June 2, 2017

City of Albuquerque
Planning Department
Current Planning Section

Re: Environmental Planning Commission
Project#: 1011188, case #17EPC-40007 May 11 – Site Development Plan for Building Permit

SOUTH ELEVATION

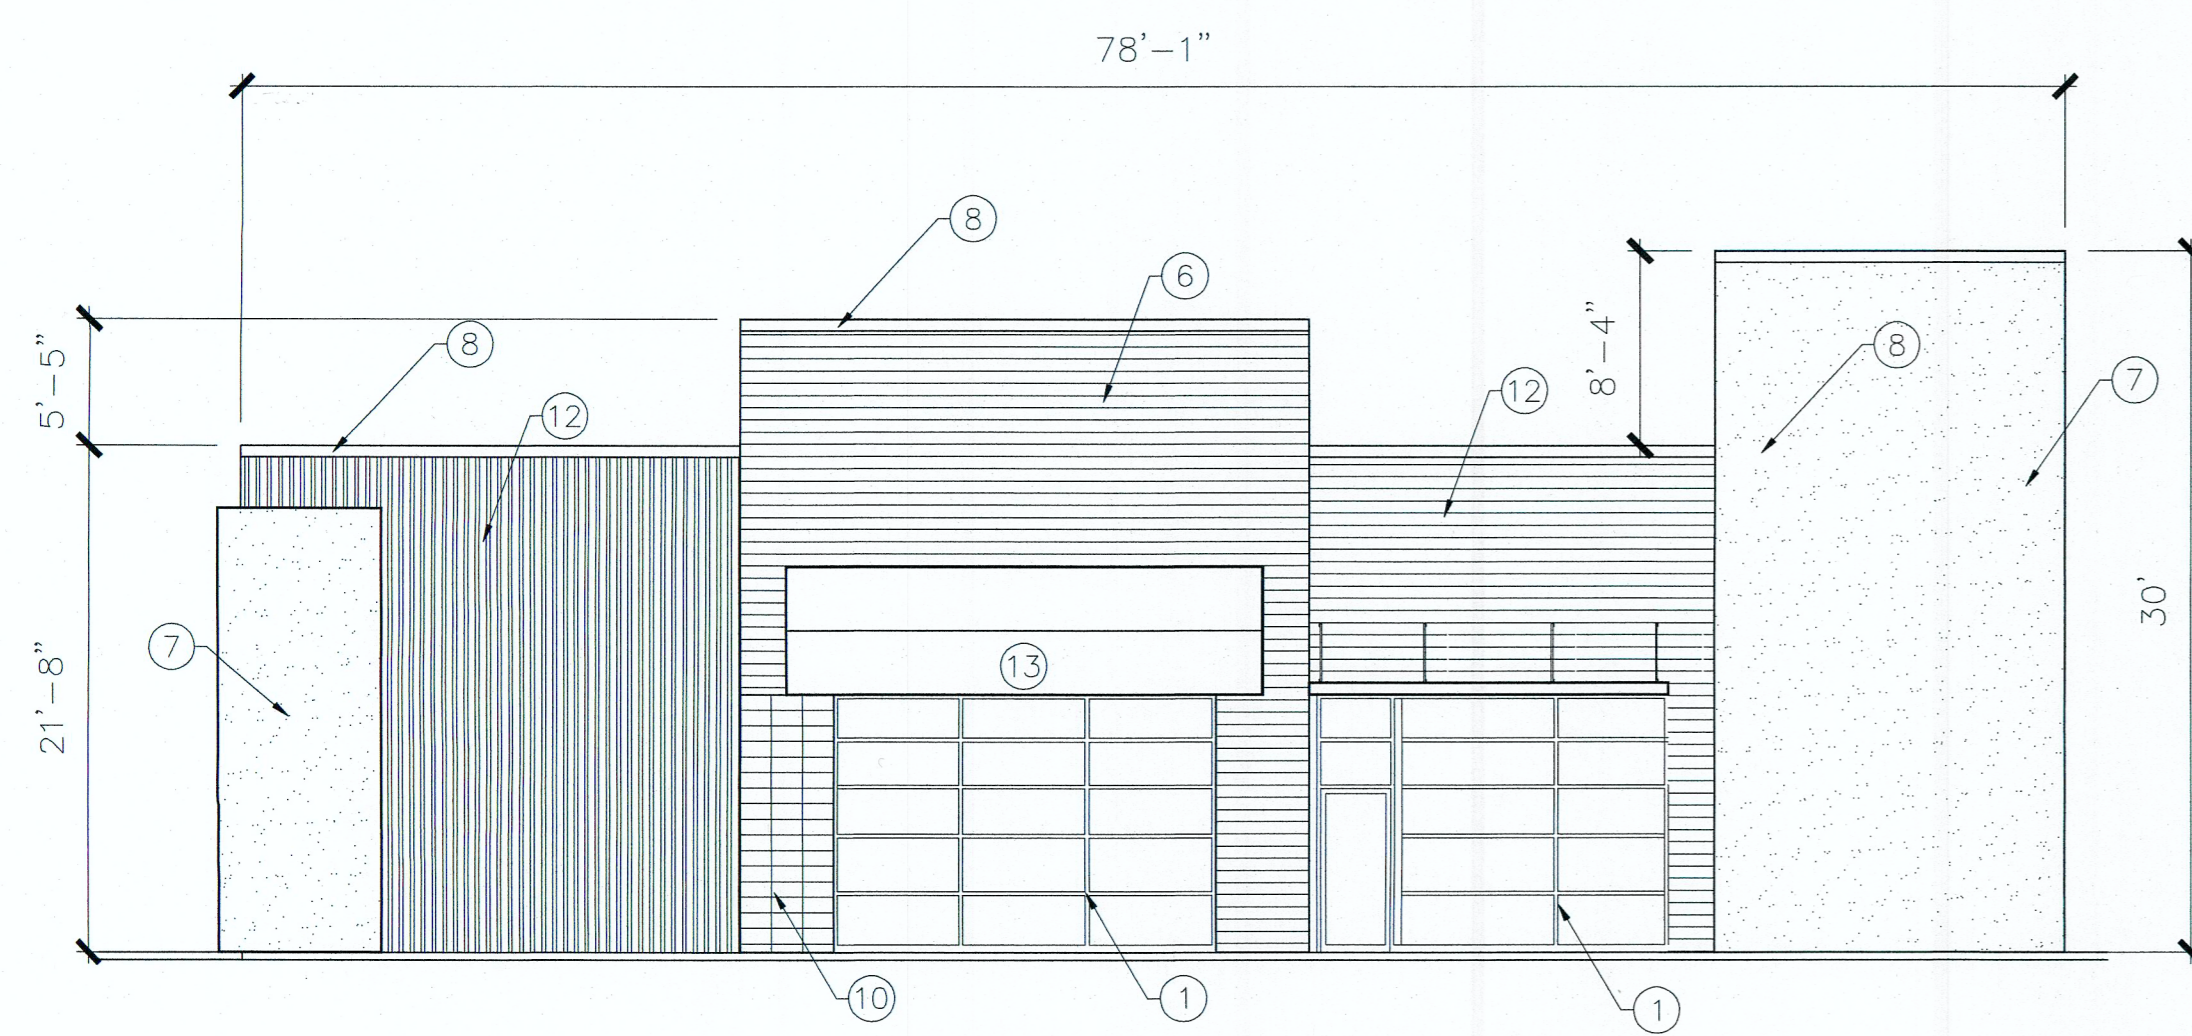
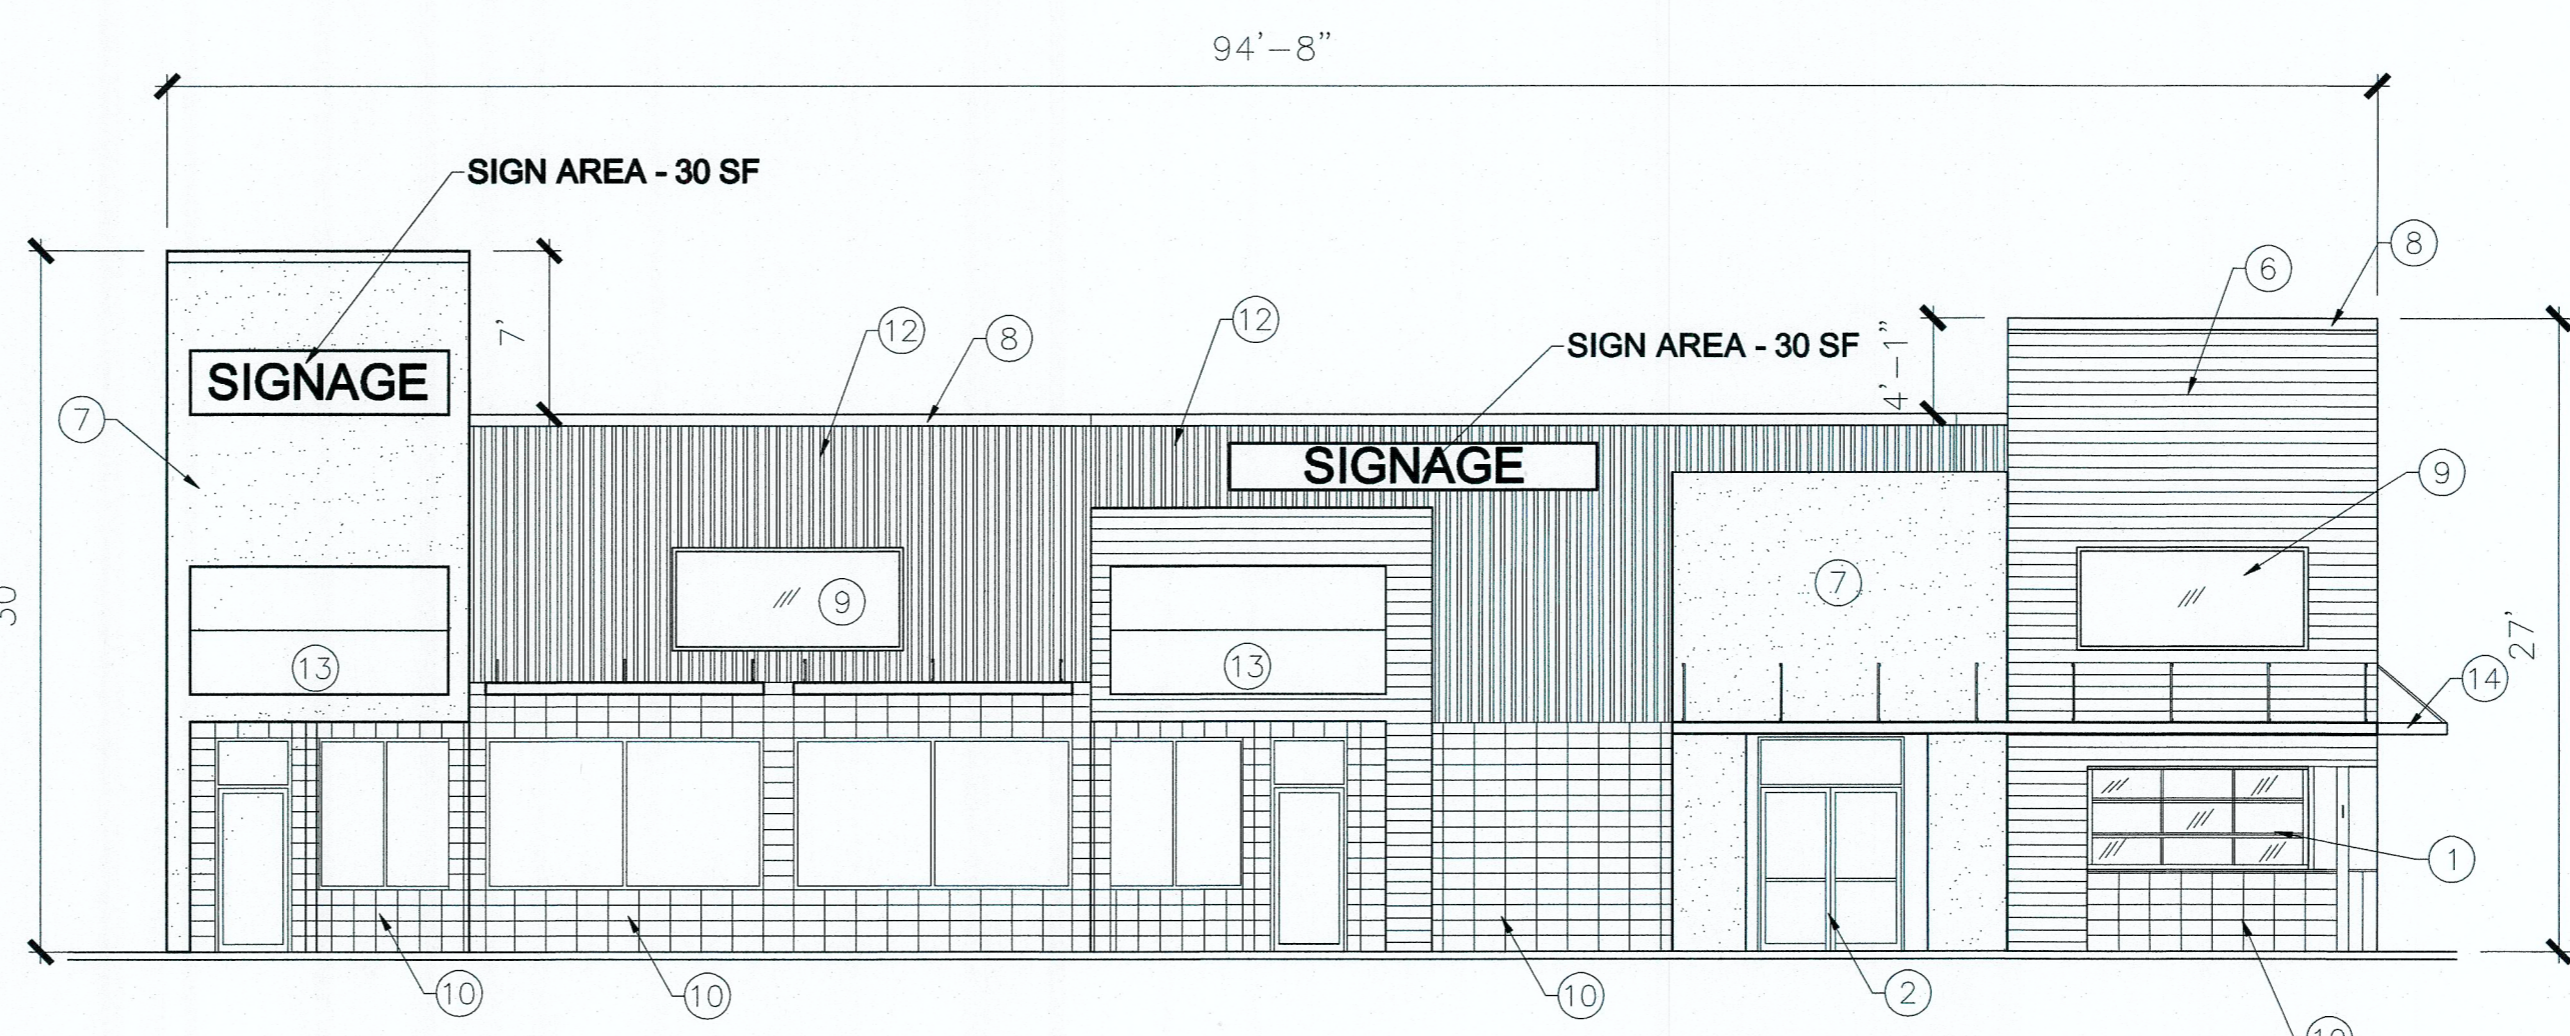
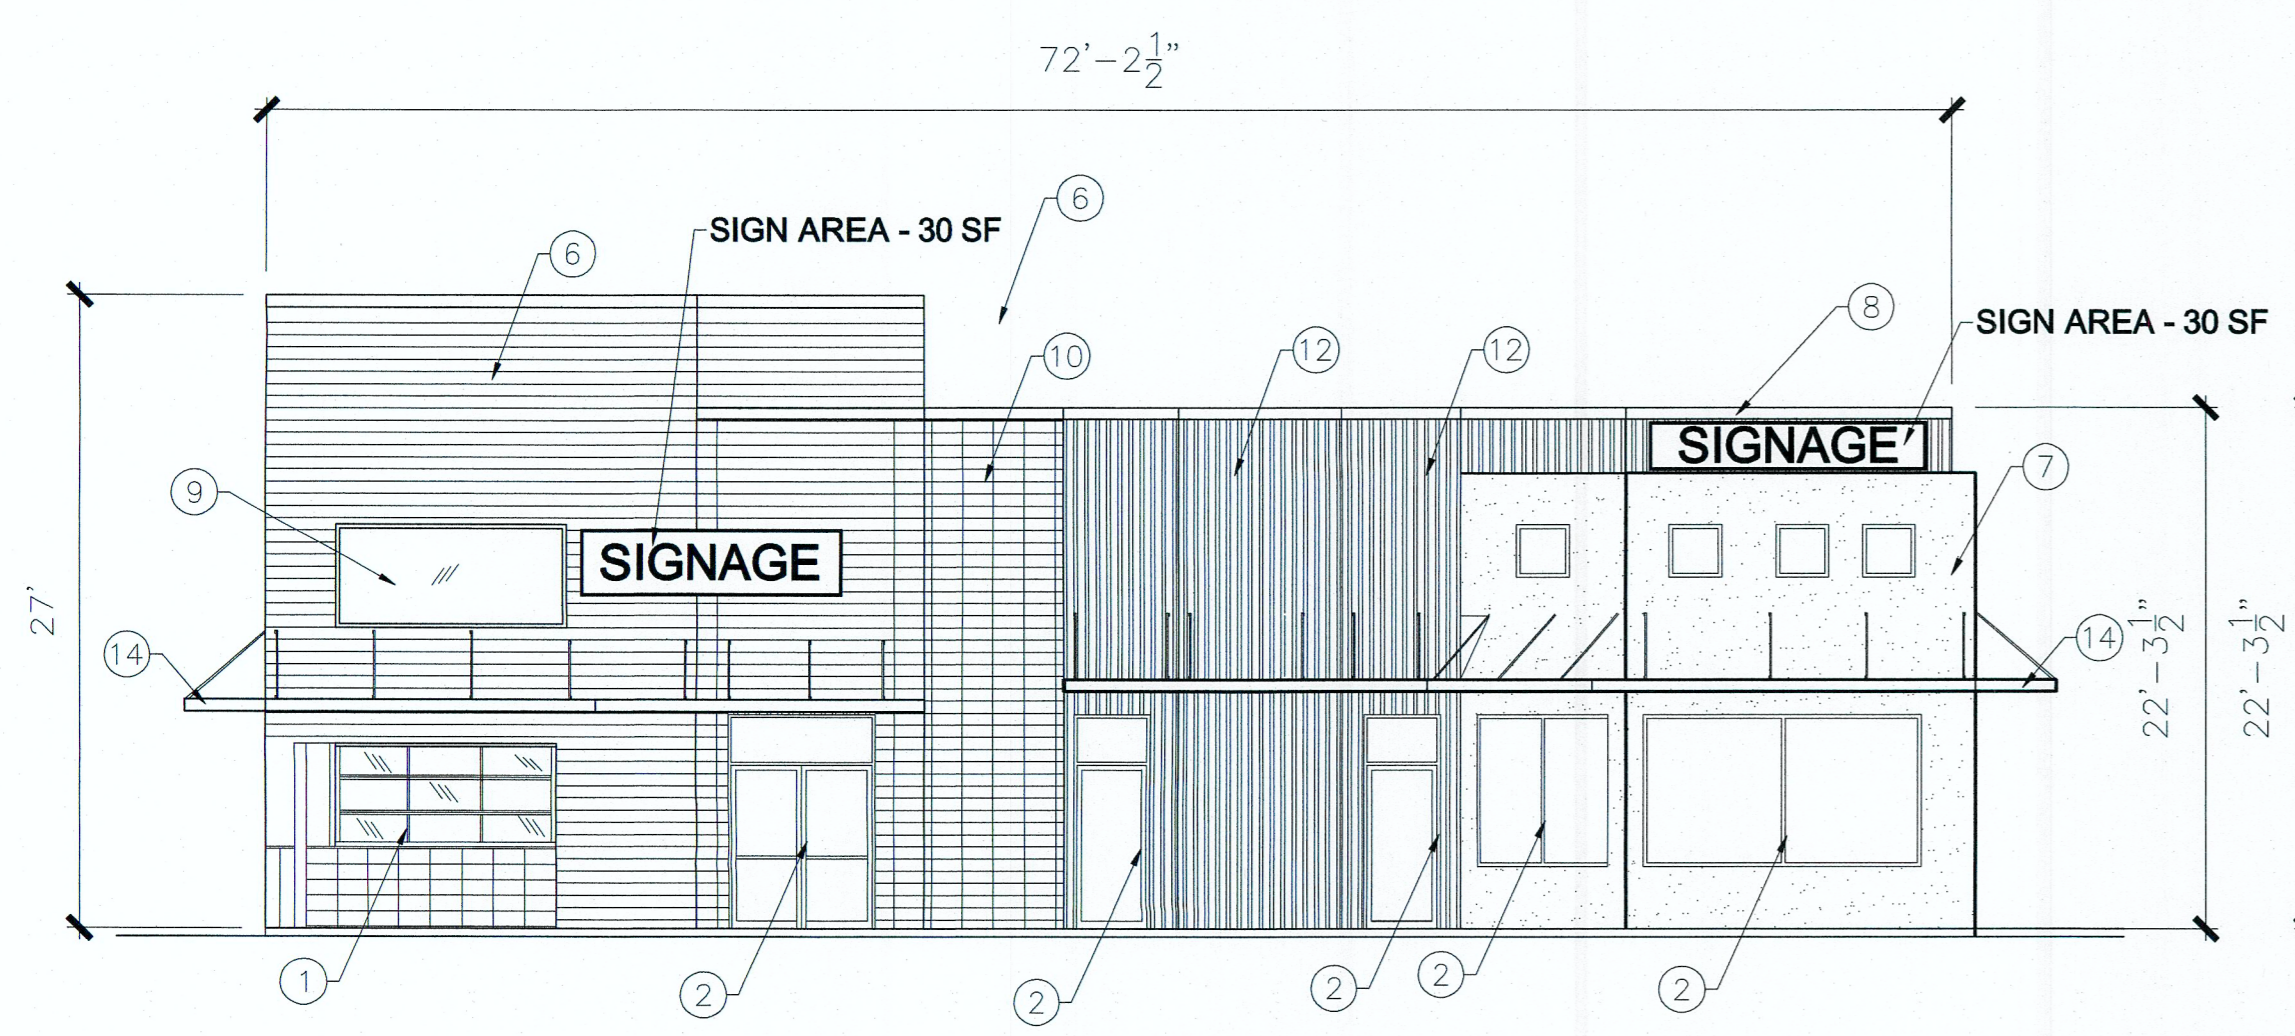
Comment Number 5: General note “B” has been added to sheet A3 to address future signage.
